RE: HOMESTEAD FILING 2 – PRELIMINARY ACCEPTANCE PUNCHLIST FOR FULL SPECTRUM DETENTION POND 1

RE: HOMESTEAD FILING 2 – VOLUME CERTIFICATION LETTER FOR FULL SPECTRUM DETENTION POND 1

RE: HOMESTEAD FILING 2 – PRELIMINARY ACCEPTANCE PUNCHLIST FOR NORTH SAND FILTER BASIN

**NORTH SAND FILTER EMERGENCY SPILLWAY**  
SCALE: 1"=2'

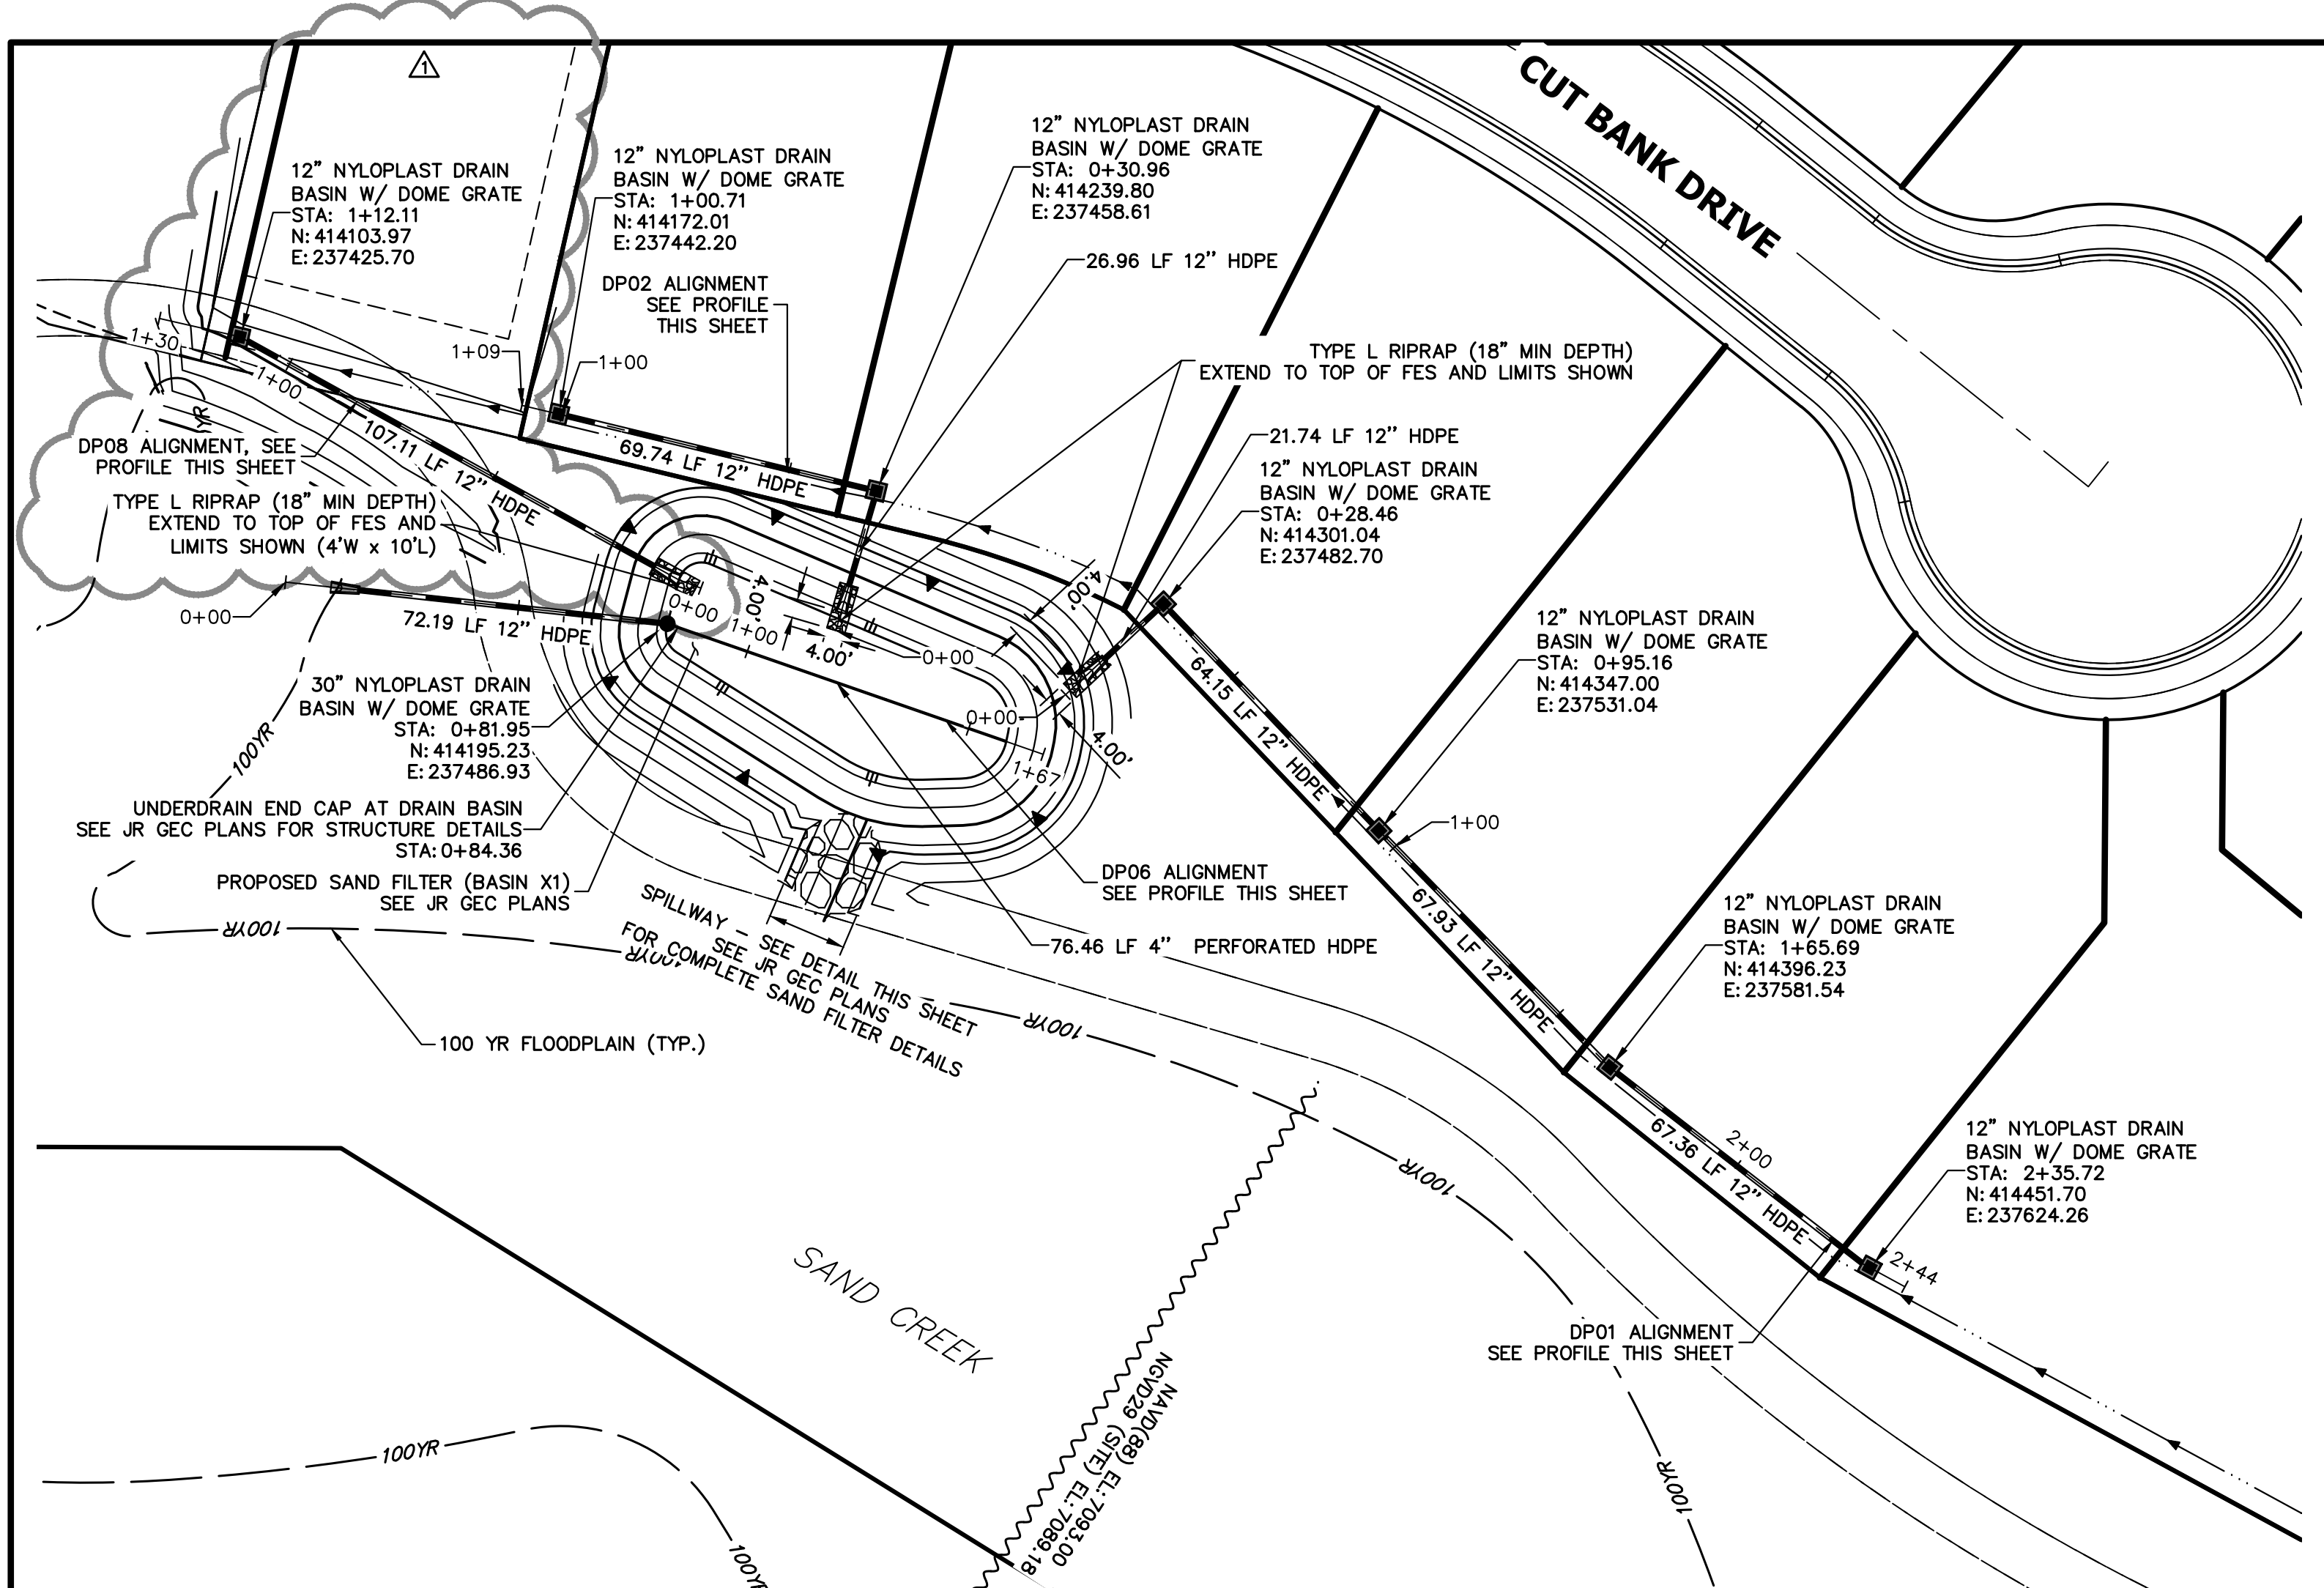
1. Spillway constructed with plain riprap instead of soil riprap

FDS POND 1 EMERGENCY SPILLWAY AND RUNDOWN TO SAND CREEK CHANNEL
1"=10'

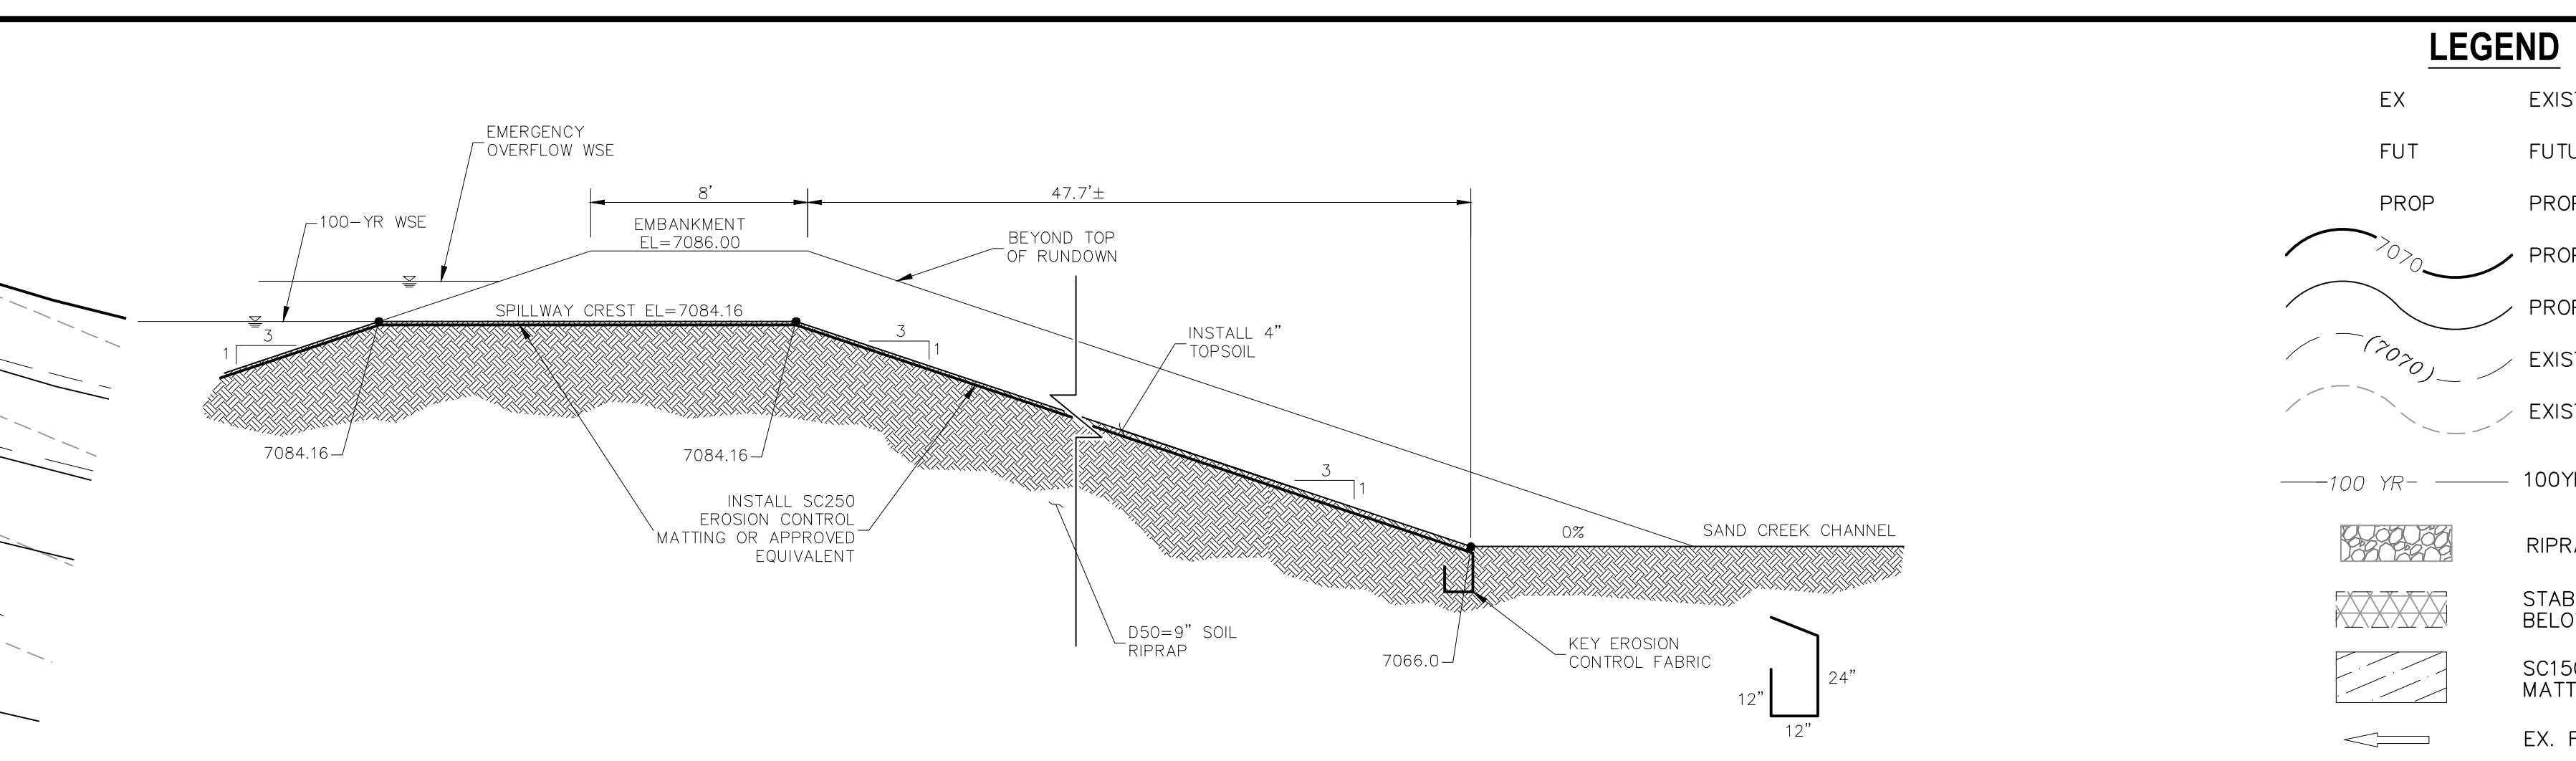
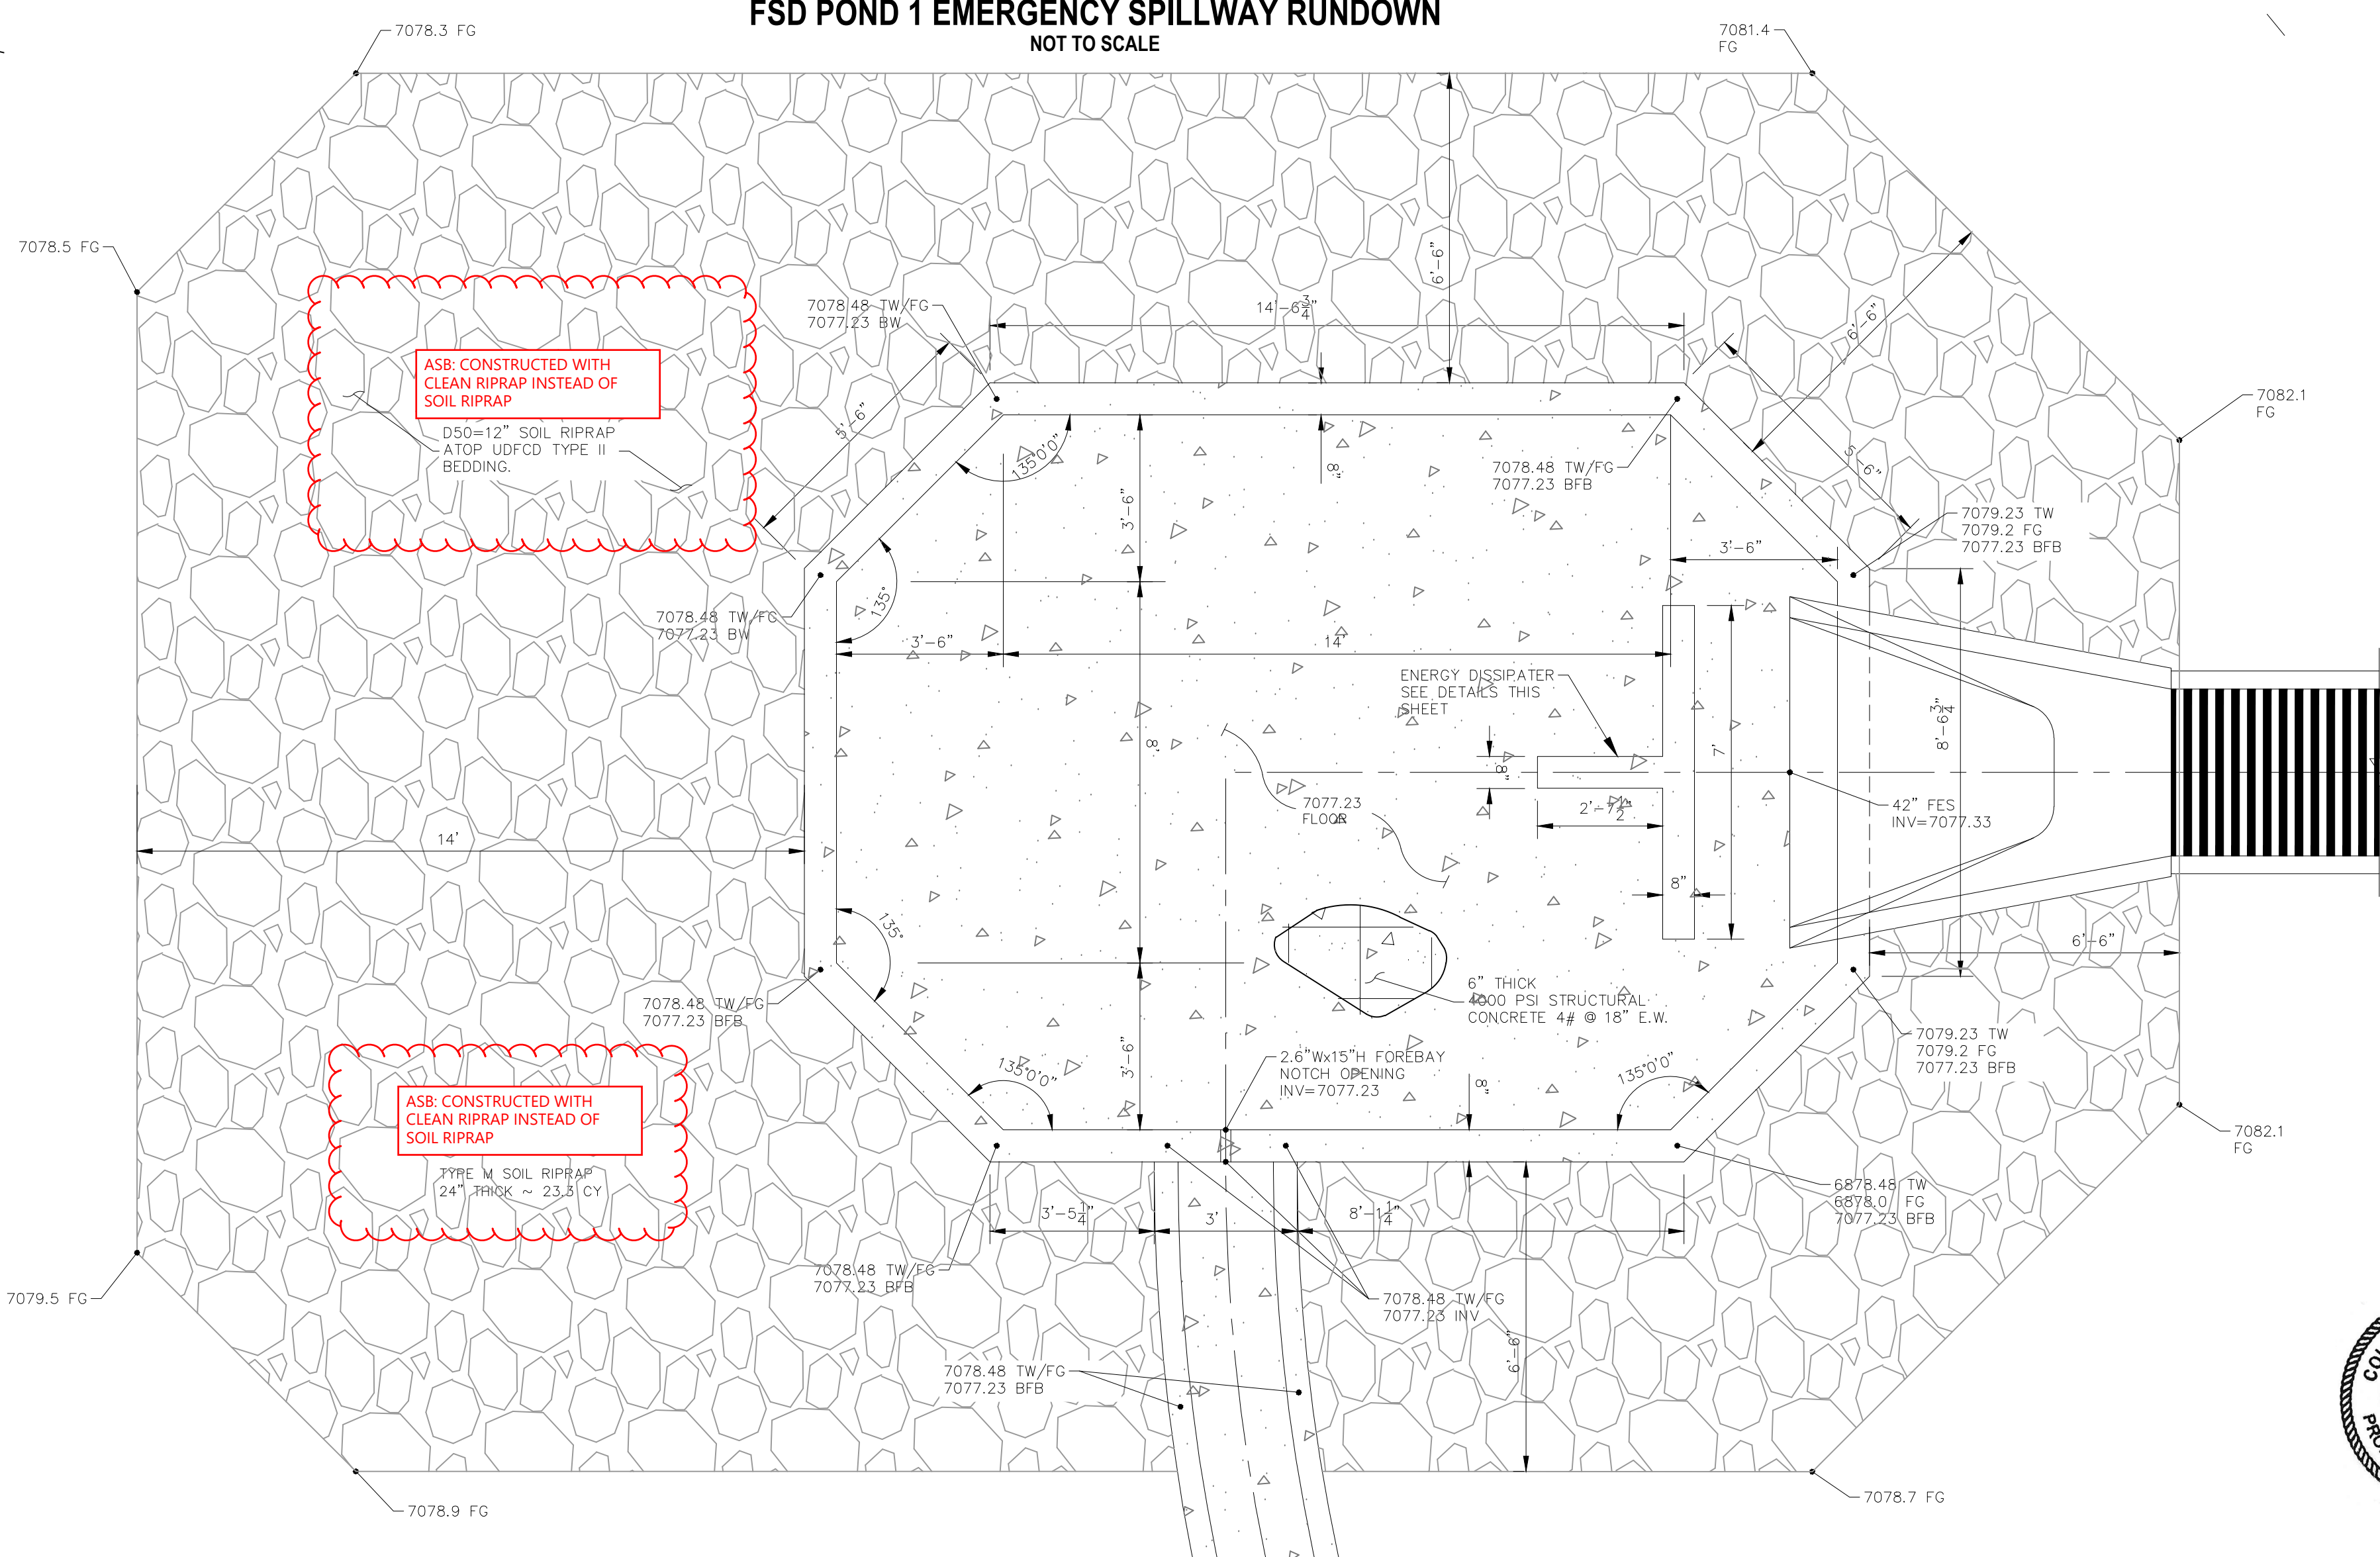
1. Micro screen installed with V-wire bars are horizontal and not vertical
2. Pond outfall not installed per plans. Plunge pool approved, 8' x 30' riprap pad installed. Discuss need for concrete cut-off wall
3. Shown plain riprap around forebay, instead of soil riprap
4. Restrictor Plate Height
5. Flat portion of Section A-A (spillway) is installed at less than 20 ft wide.

Spillway Width

The spillway was proposed at 20' in the approved construction documents. However, it was constructed 16' wide. The UD-Detention 3.07 spreadsheet for Pond 1 has been updated with the 16' spillway width and confirms the spillway will pass the undetained 100-year flow with 1.0' freeboard. Therefore, I recommend the 16' spillway remain as is.

FOREBAY PLAN
SCALE: 3/8" = 1'

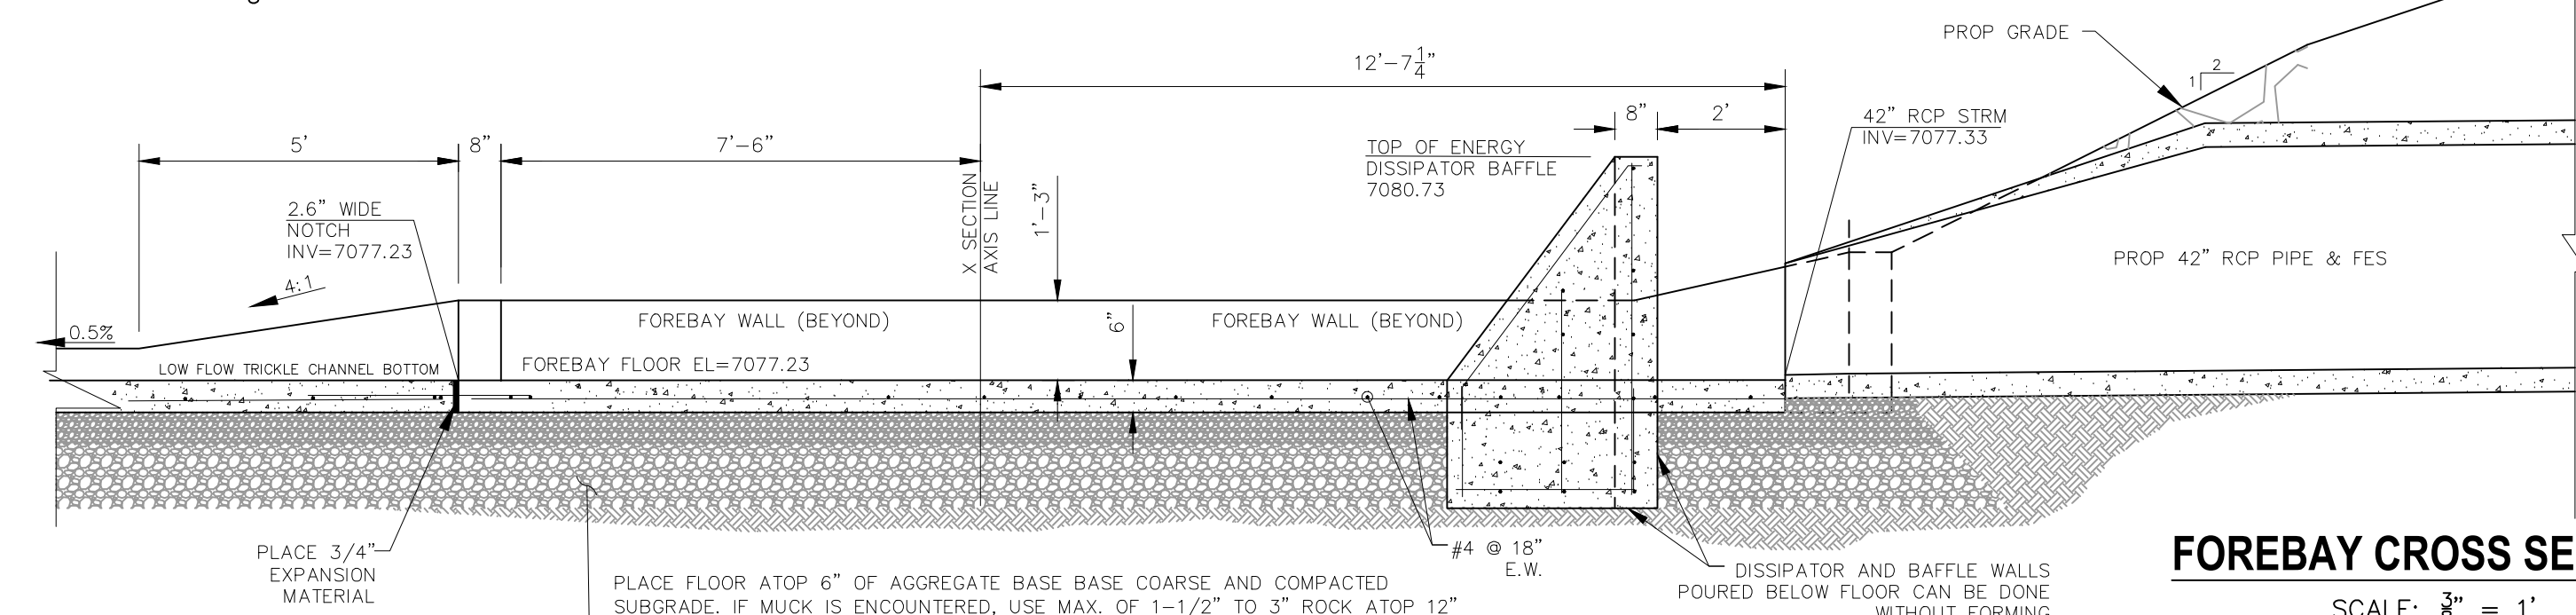
Forebay Riprap

The reason for calling out soil riprap for the forebay protection is that soil riprap gives a finished look and can be revegetated, however; both clean riprap and soil riprap are acceptable erosion protection treatments around the forebay. Therefore, I recommend the clean riprap remain around the forebay.
